Application by Highways England for a Development Consent Order in relation to the A585 Windy Harbour to Skippool Improvement Scheme

The Examining Authority's Additional Written Questions and requests for information (ExQ3)

Issued on 19 August 2019

**KEY:**

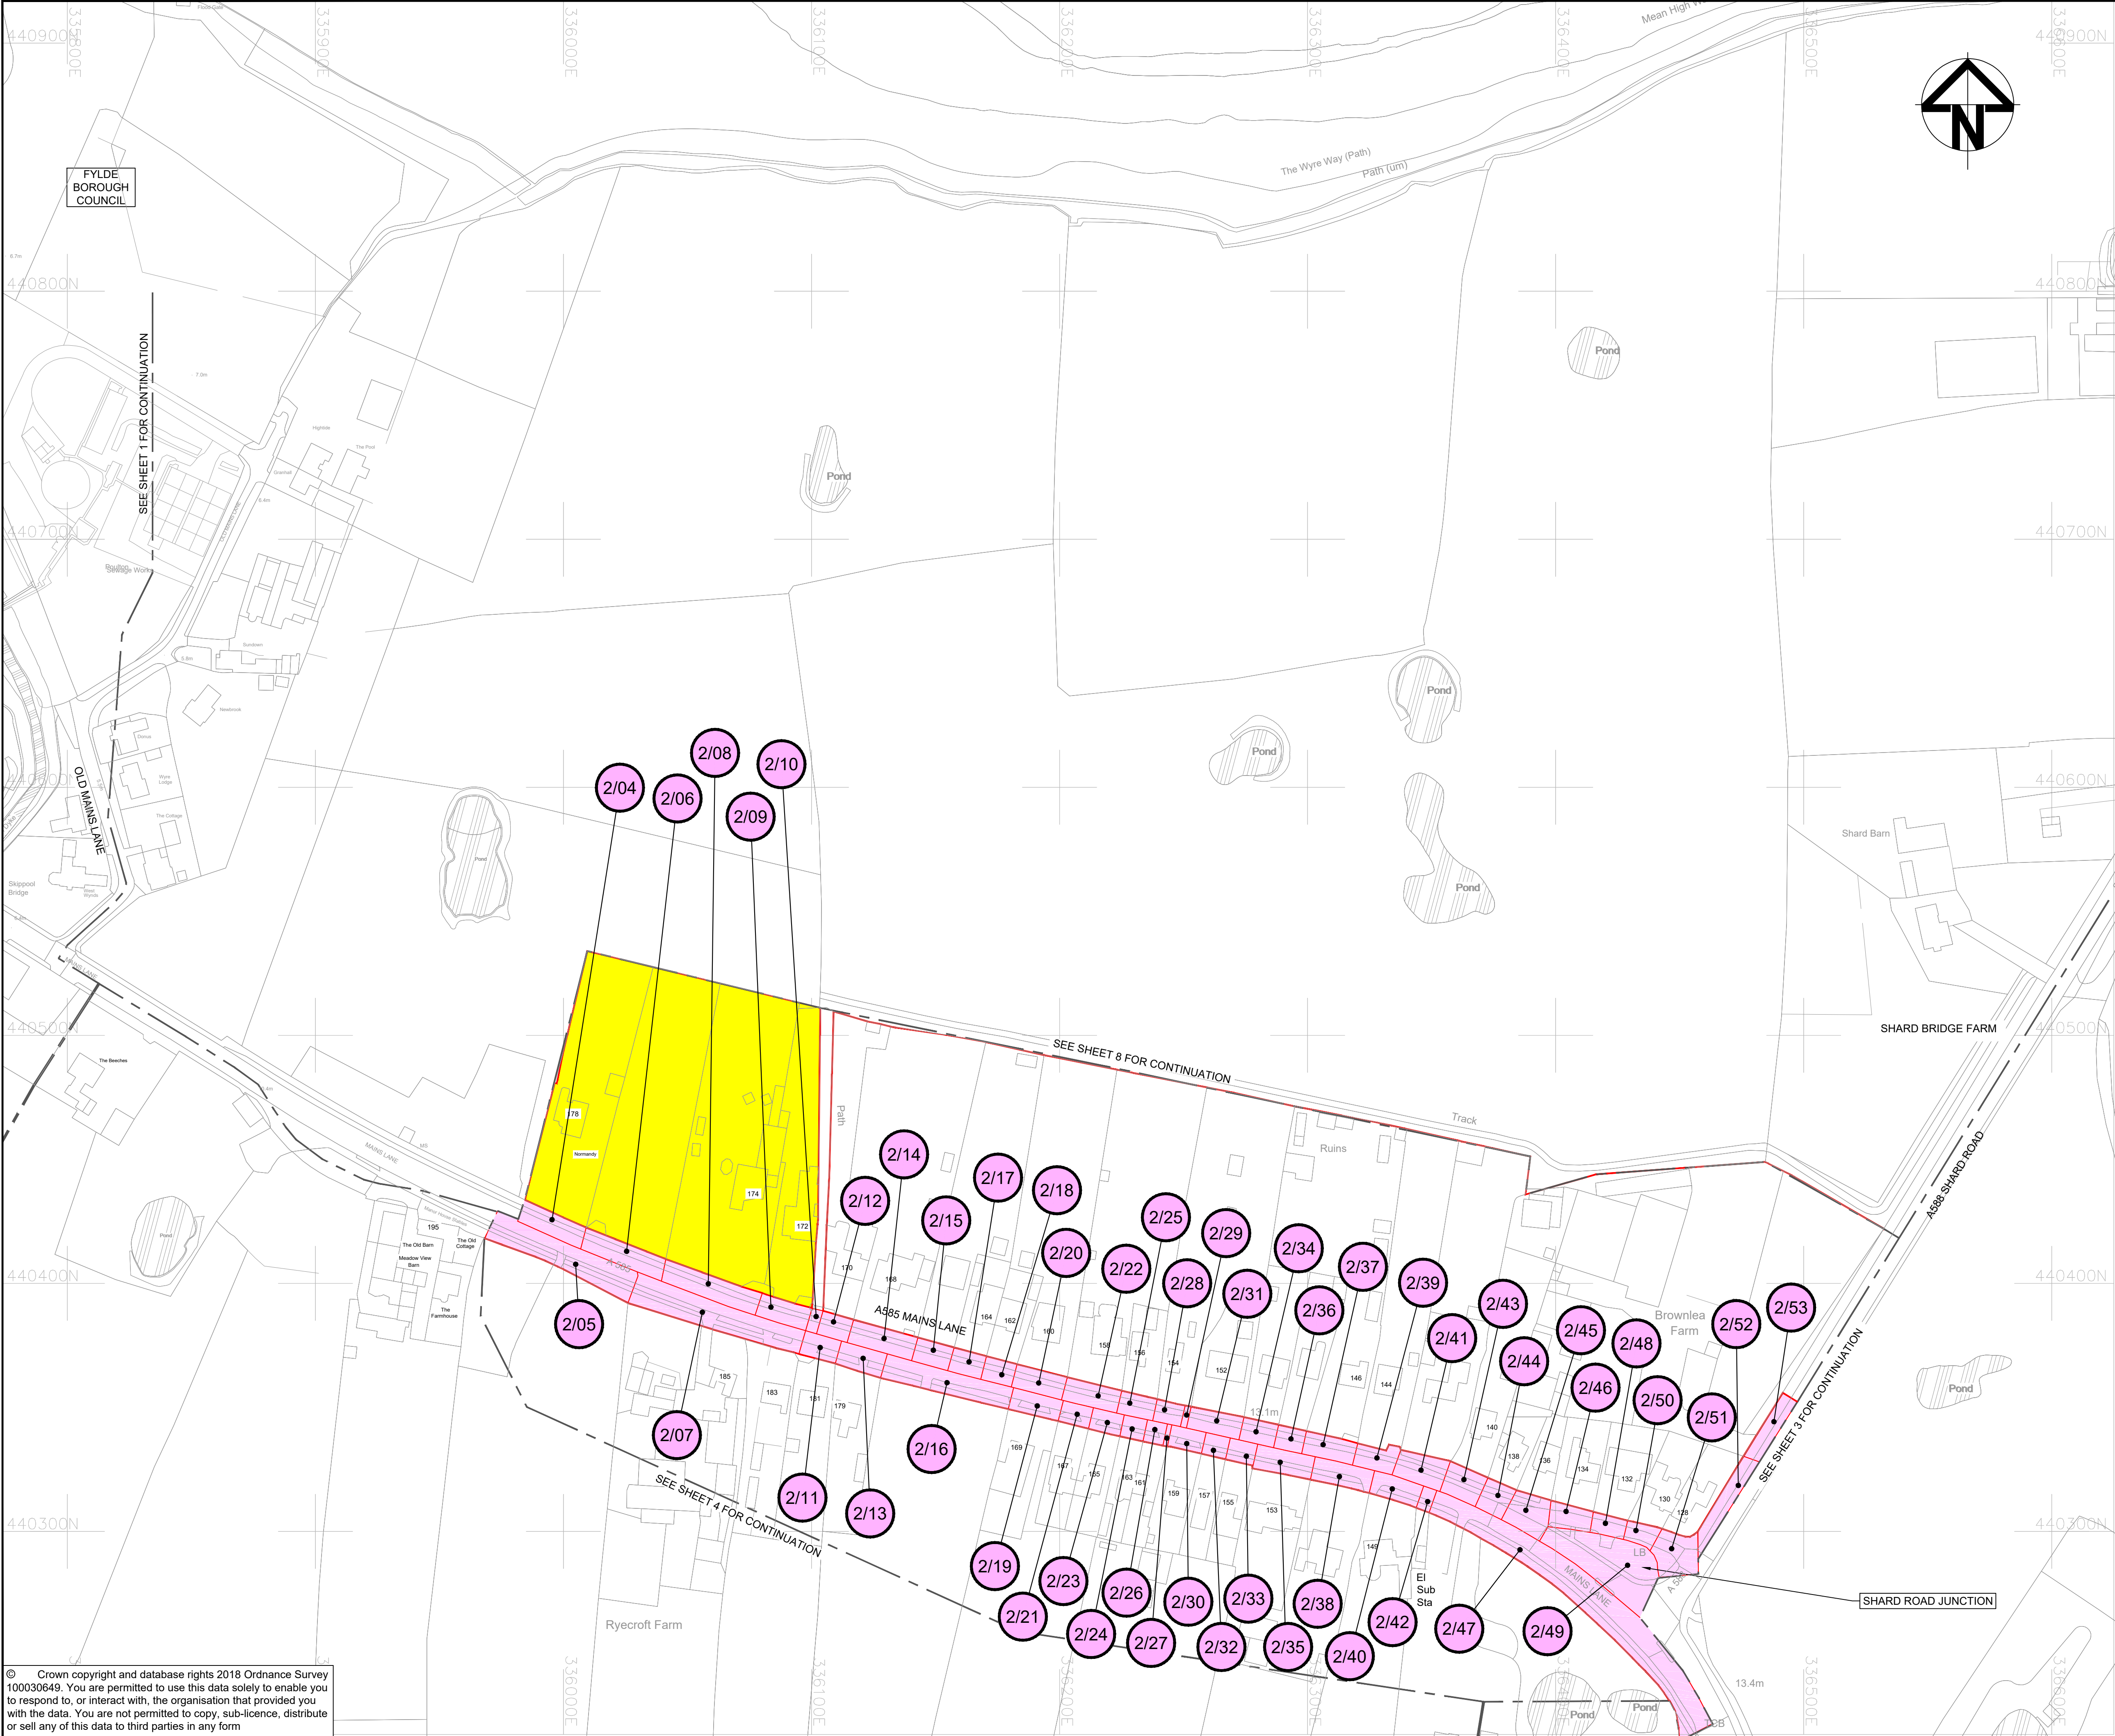
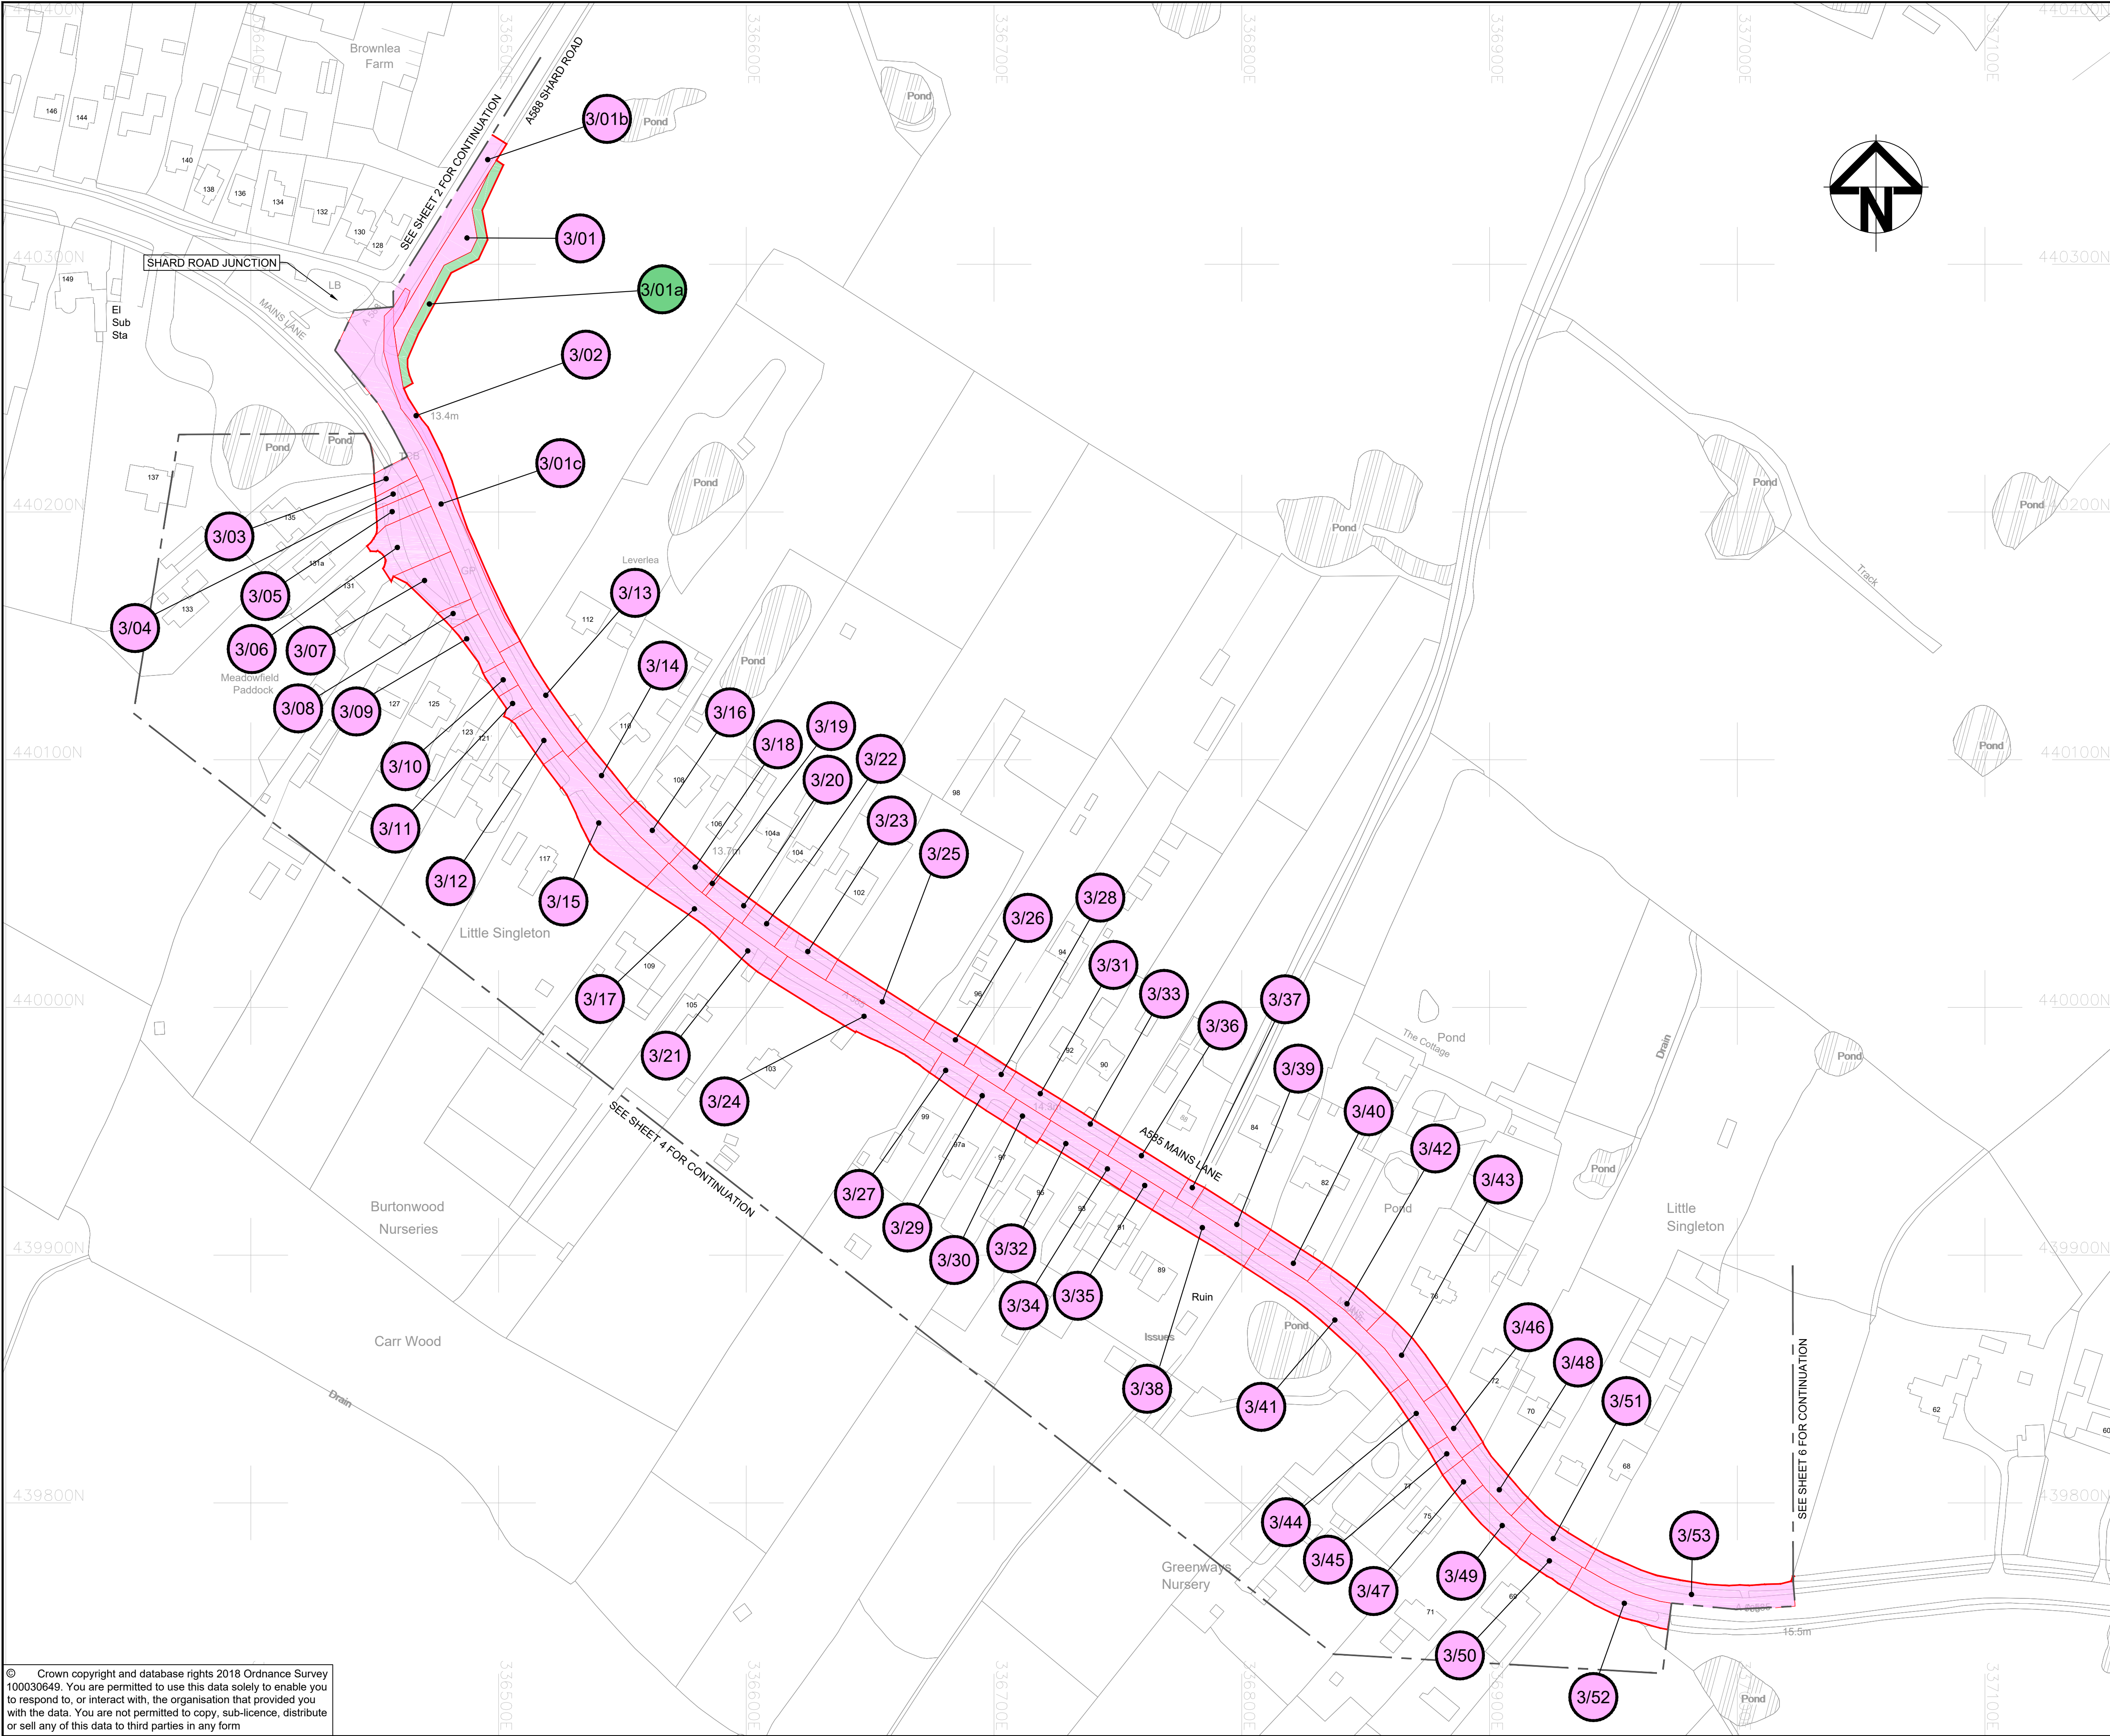
3.2.27.	The Applicant	<p>Area not included in the DCO boundary The ExA still does not understand what the land coloured yellow on the plans is for, or why it is identified on the plans at all. The Applicant has not explained this in their response. If the land is not required for any works or required to be acquired permanently or used temporarily why is it highlighted on the plans? It is also confusing for it to have a red boundary if the intention is for this area to be outside of the draft order limits which are defined by a red boundary. Please explain the reasons for the above?</p>
